SYDNEY OLYMPIC PARK AUTHORITY DESIGN REVIEW PANEL – ADVICE SHEET

Project	Sites 2A and 2B – Australia Ave, Sydney Olympic Park	
Presentation / Review Date	31 October 2018	
Panel Present	Ingrid Mather Caroline Pidcock Michael Harrison	JMD Design (Chair) Pidcock Architects Architectus
COI Declaration	None	
Also Present	Alix Carpenter, Ben Woods, Dylan Sargent and Catherine Modini (SOPA) Daniel West and Candice Pon (Ethos Urban) Bassam Afflak and Michael Azar (Ecove)	
Presenters	James Fitzpatrick (Fitzpatrick + Partners) Matthew Mar (Fitzpatrick + Partners) Michael Barnett (Arcadia)

2A LEVEL 15 - 29 TYPICAL HOTEL

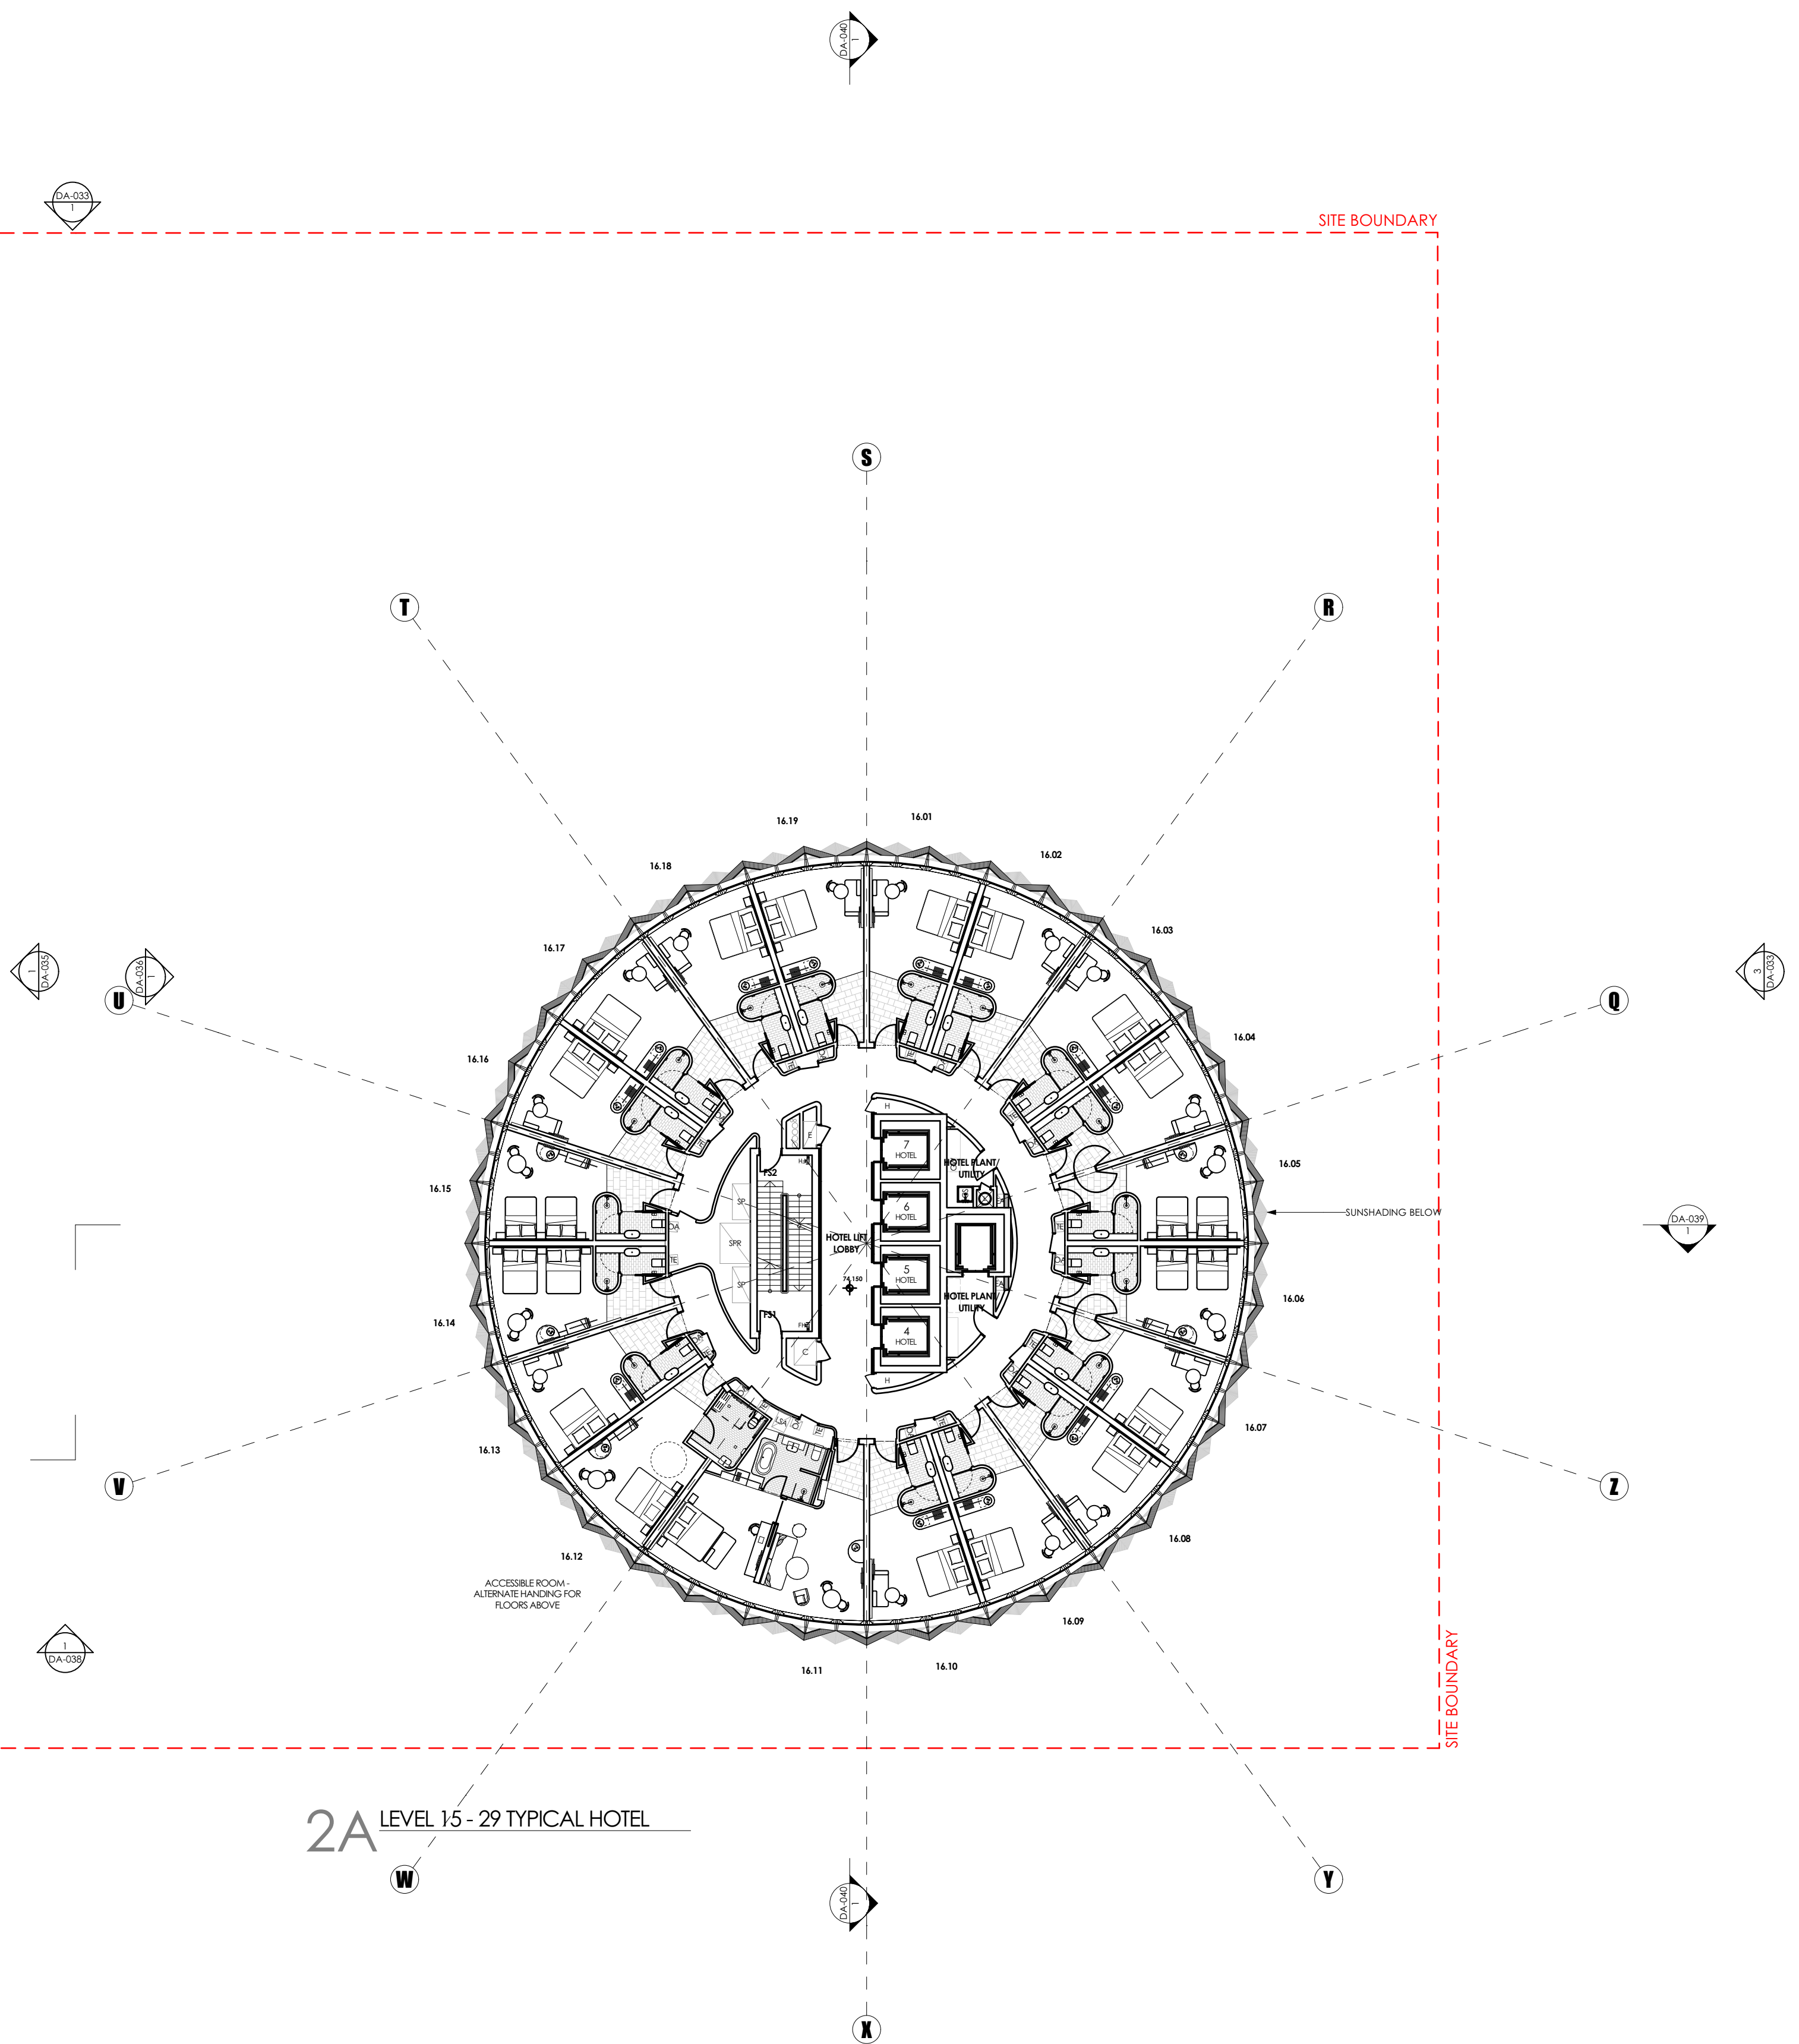
2. Outlook from lift foyer of hotel and serviced apartments:

Fitzpatrick + Partners presented two options to incorporate natural light and an outlook from the lift foyers. Option 1 involved creating a splayed viewing corridors on either side of the lift foyer that are approximately 800mm wide at the corridor. Given the 8m depth of the hotel rooms either side of the corridor, Option 1 was considered unlikely to provide significant natural light to the lift foyers and would present significant maintenance issues.

Option 2 involved the deletion of one room from each level to create an outlook and lounge area. This option was deemed financially unviable.

Fitzpatrick + Partners expressed their preference to maintain the internalised corridor and create a response with a changing façade design and lighting to assist with internal navigation.

3. Solar access and natural ventilation of habitable areas in hotel and serviced apartments:

Fitzpatrick + Partners presented revised floor plans for the hotel rooms, which placed bedrooms and living areas along the facade and internalised non-habitable areas such as bathrooms and kitchen areas.

Fitzpatrick + Partners also presented an option for a hinged window to provide natural ventilation to the serviced apartments but advised that the hotel operator would not accept operable windows for hotel rooms.

1. The Panel supported the design development of the façade and recommended that further development continue to be undertaken to optimise solar performance.
2. The Panel supported the decision not to include an outlook or natural lighting from lift foyers but resolved that the internal hallway design concepts needed to be further developed. In particular,

the Panel identified the opportunity to incorporate circadian lighting changes and possibly biophilic design into the hallways.

3. The Panel supported the revised room layouts and inclusion of operable windows to the serviced apartments. The Panel re-iterated their preference for natural ventilation to the hotel rooms and recommended that further design development continue to explore this as an option.
